M60/M62/M66 Simister Island – TR010064

Section 51 advice regarding draft application documents submitted by National Highways

The advice recorded in the table below relates solely to matters raised upon the Planning Inspectorate's review of the draft application documents listed above. The advice is limited by the maturity of the documentation provided by the Applicant and the time available for consideration and is raised without prejudice to the acceptance decision or the final decision about whether development consent should be granted.

Drawing number: HE548642 - ARD - LDC - SII_MLT
 Originator: ARD
 Volume: -DR- Z -0002

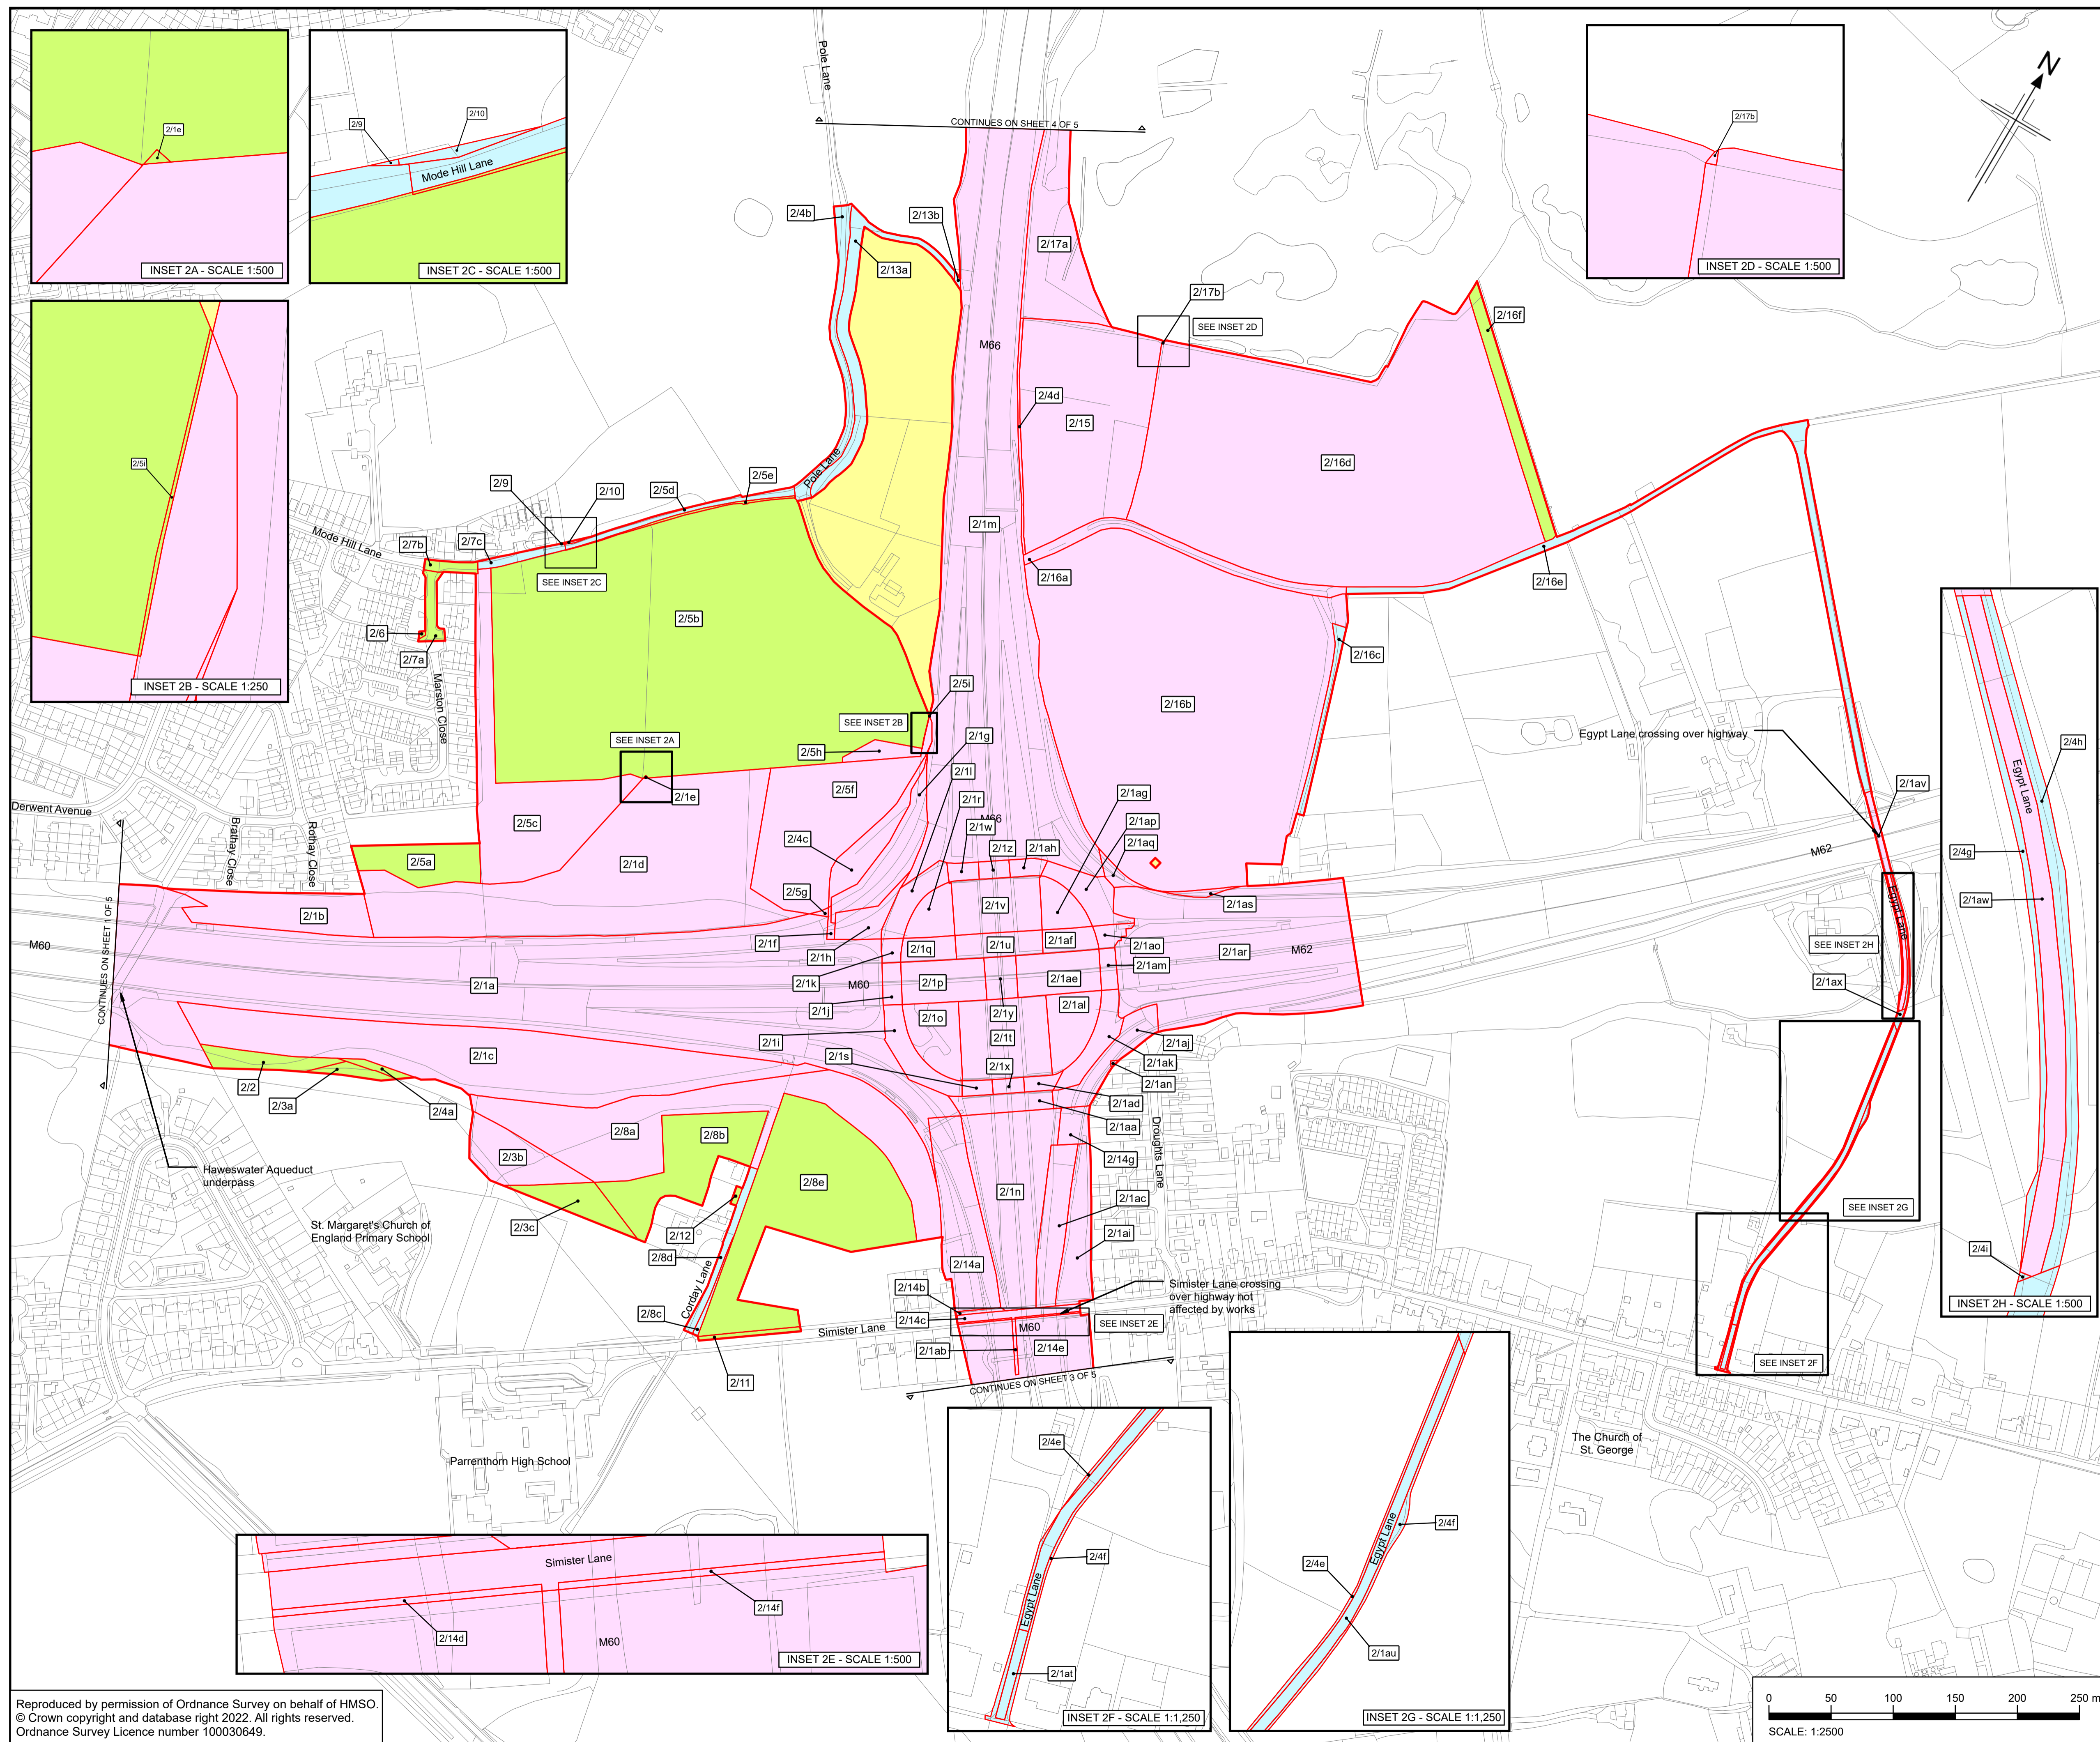
Land Plan		
Ref No.	Plan ref	Comment/Question
28.	All	'Land to be acquired' in key is permanent acquisition, This could be changed to state 'land to be permanently acquired' to help distinguish.
29.	P01 – Sheet 1	Plot 1/1k – coloured as 'land to be acquired' on plan but labelled in BoR as 'temporary possession'.
30.	P01 – Sheet 1	1/34 label is covering 'Sandy Gate Road' label.
31.	P01 – Sheet 1	Plot 1/7 is missing from the plan.
32.	P07 – Sheet 1	Plot 1/8a, 'Kensington Street' needs labelling on plan.
33.	P07 – Sheet 1	Plot 1/21 is labelled as 'permanent acquisition' in BoR but coloured as 'temporary possession'
34.	P07 – Sheet 1	'Conisborough Place' is labelled 'Place Conisborough' on the plan
35.	P07 – Sheet 2	Plot 2/5b is labelled as 'permanent acquisition' in BoR but coloured as 'temporary possession'. Please amend.

FIGURE 2.1

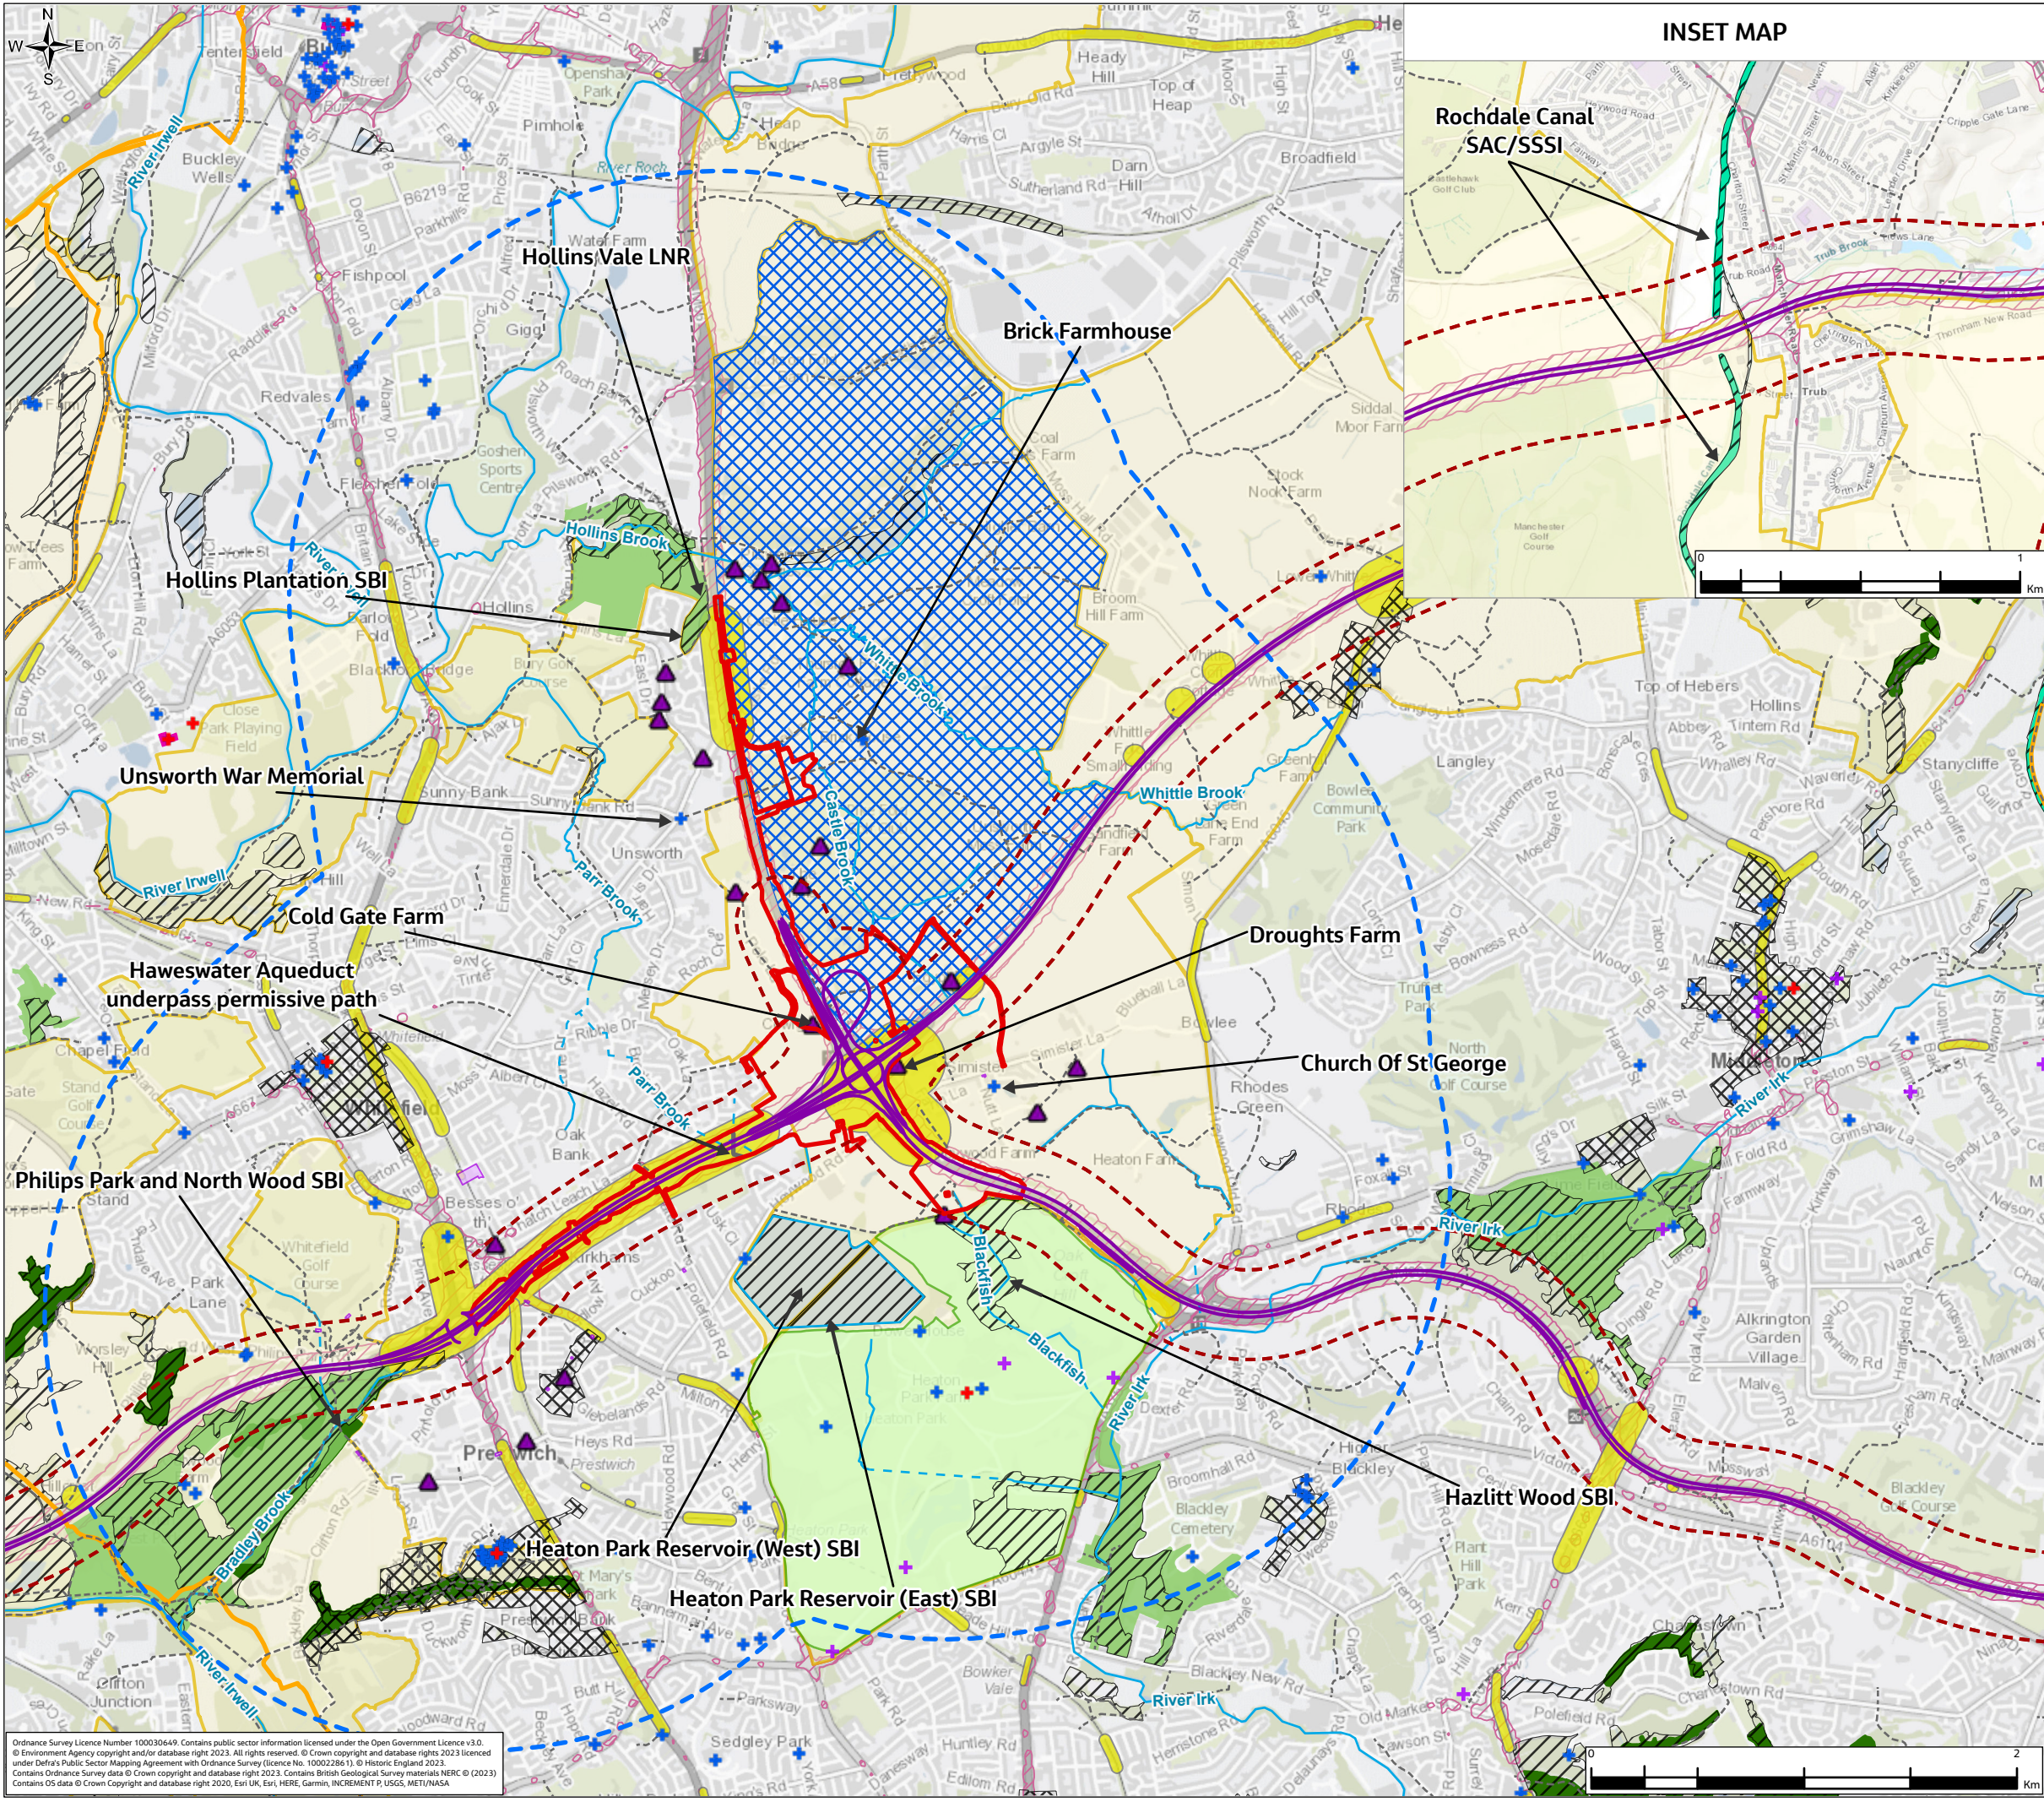
Environmental Statement Figure 2.1 Environmental constraints		
Ref No.	Paragraph/Section	Comment/Question
23.	ES Figure 2.1 and ES Chapter 2 Paragraph 2.4.2	ES Figure 2.1 does not depict all the constraints listed in ES Chapter 2, Paragraph 2.4.2 such as Mineral Safeguarding Areas, Rochdale Canal Special Area of Conservation (SAC) and Rochdale Canal Site of Special Scientific Interest (SSSI). The Applicant should ensure that all relevant constraints are clearly depicted on ES Figure 2.1. In addition to this, the applicant should provide clearer labelling of the relevant constraints, such as clarifying that it is the Greater Manchester Air Quality Management Area (AQMA) depicted on the figure.
